Office of
Environment
& Heritage

DOC16/102260-2
SSD 5850

RE: Mount Owen Continued Operations Project (SSD 5850)

Likely impact of the expansion of North Pit in relation to proposed vegetation corridors

Mount Owen Continued
Operations Project
Habitat Linkages

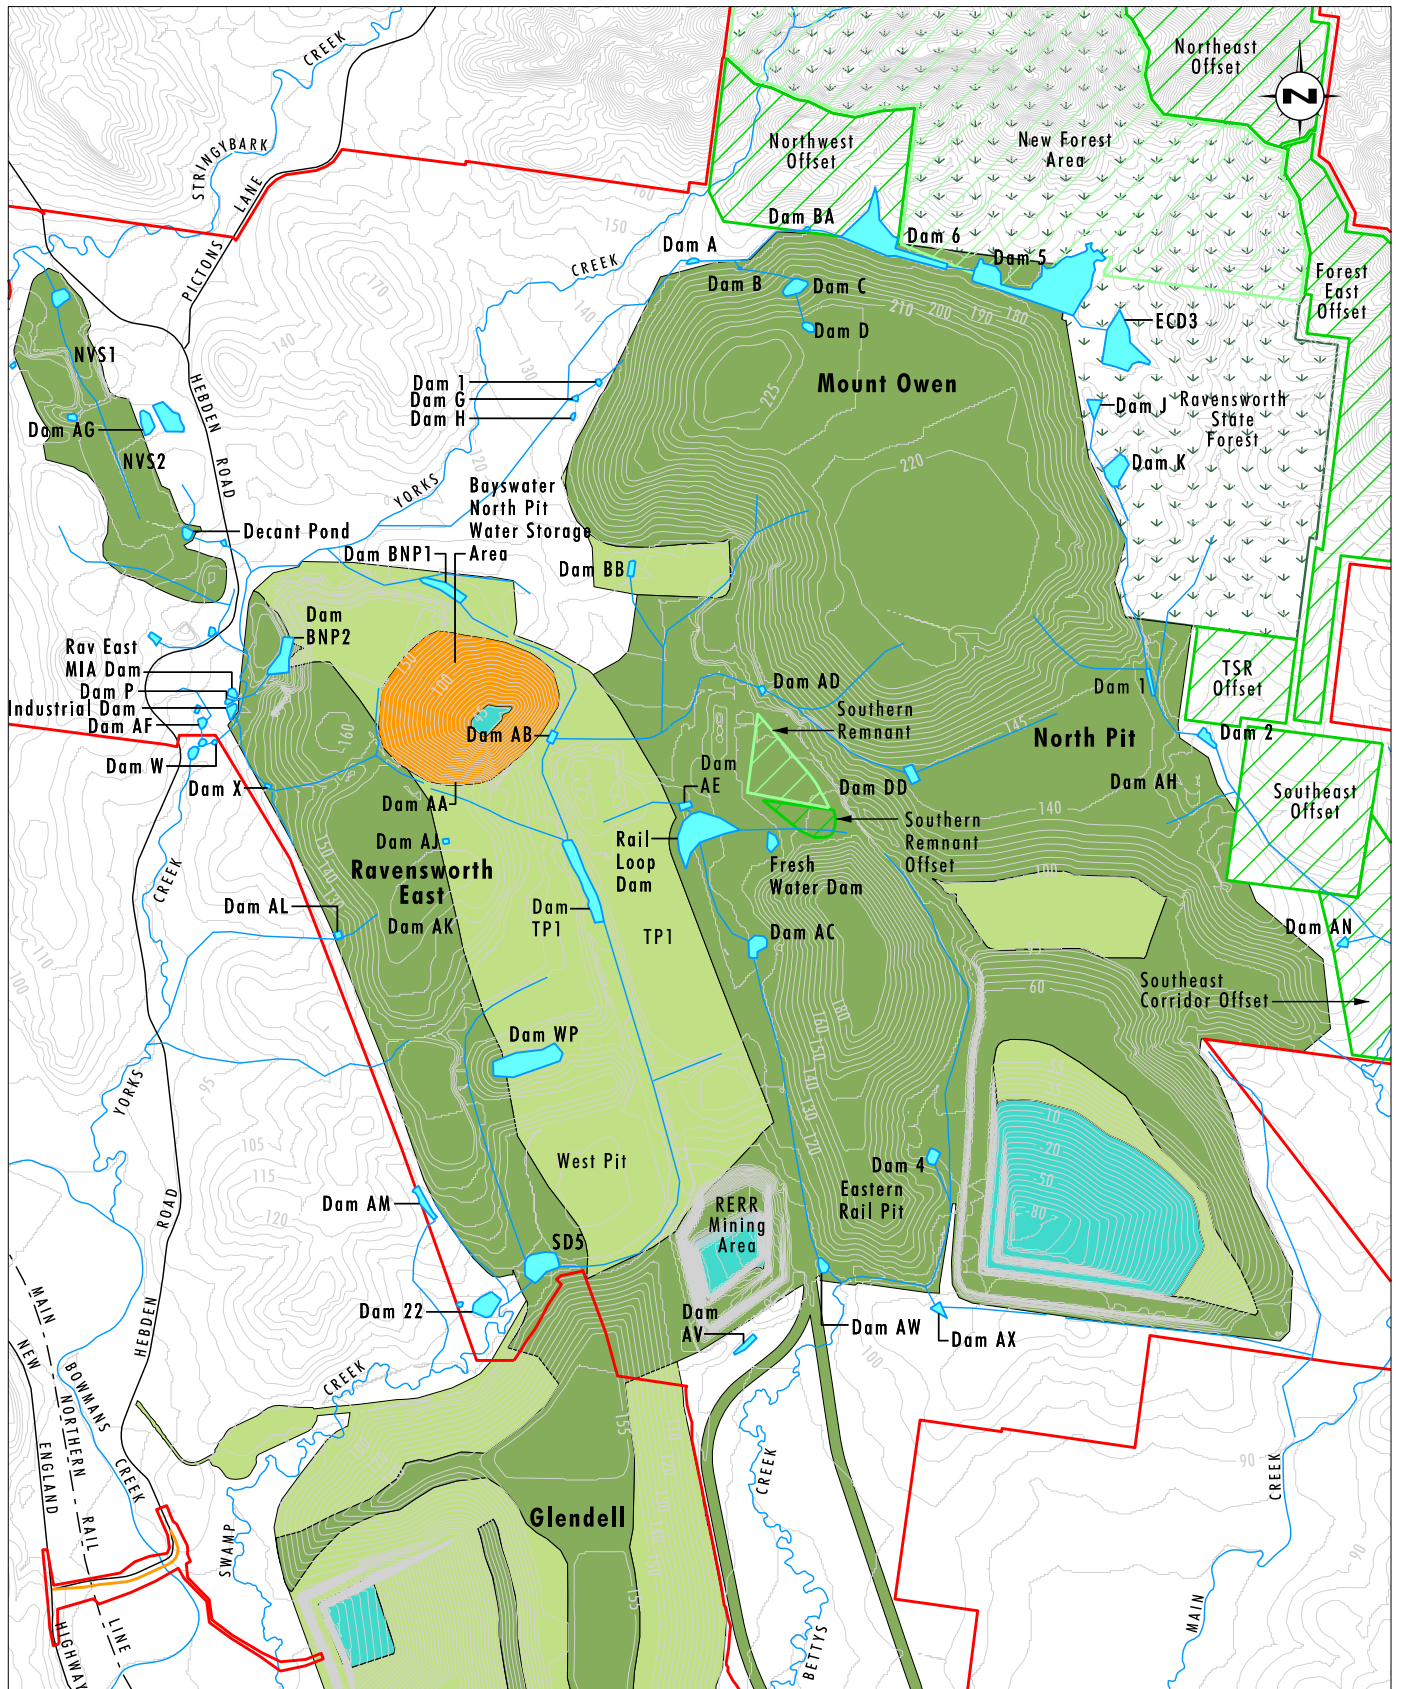
The proposal includes plans to bolster vegetated corridors around the project area through a combination of active and passive revegetation at the Cross Creek offset, the Stringybark Habitat Corridor, the Betty's Creek Habitat Management Area, and the inclusion of wooded corridors in the rehabilitation of post-mined areas within and west of North Pit.

The remaining 164 hectares of the North Pit expansion footprint comprises derived native grasslands of the local woody vegetation communities in Table 1, and about one hectare of water bodies (mostly farm dams) (Umwelt (Australia) Pty Ltd (2014)). The loss of vegetation in the North Pit development footprint would reduce the width of the wooded corridor from about 1.2 kilometres to 600 metres around

the southern part of the Betty's Creek Diversion, and would remove the main area of remnant Dry Sclerophyll Forest and Woodland on the western side of Main Creek in the area south of North Pit.

The reduction in width of the corridor and the loss in habitat features found in those areas is likely to impact on local threatened fauna that may use them. However, the extent of impact in relation to movement and habitat of individual species is difficult to quantify.

In order to more completely consider the impact of clearing on the integrity of the north-south corridor to the east of North Pit, OEH suggests that clarification is sought on the following points:

- the suitability of the proposed corridor/patches for selected fauna species
- vegetation structure and composition of remnant, regenerating and recreated woody vegetation within the corridor
- the location and abundance of habitat features within the corridor (piles of logs, hollow-bearing trees, riparian corridors) and opportunities to source them from the development areas
- how clearing and revegetation can be staged to maximise the width of the corridor at all times (e.g. early commencement of revegetation in narrowest parts of the corridor, and delayed clearing in parts of the development footprint)
- confirmation on whether the upper reaches of the Betty's Creek diversion that are in the development footprint will need to be reinstated, and if so how much clearing in the corridor may be required?
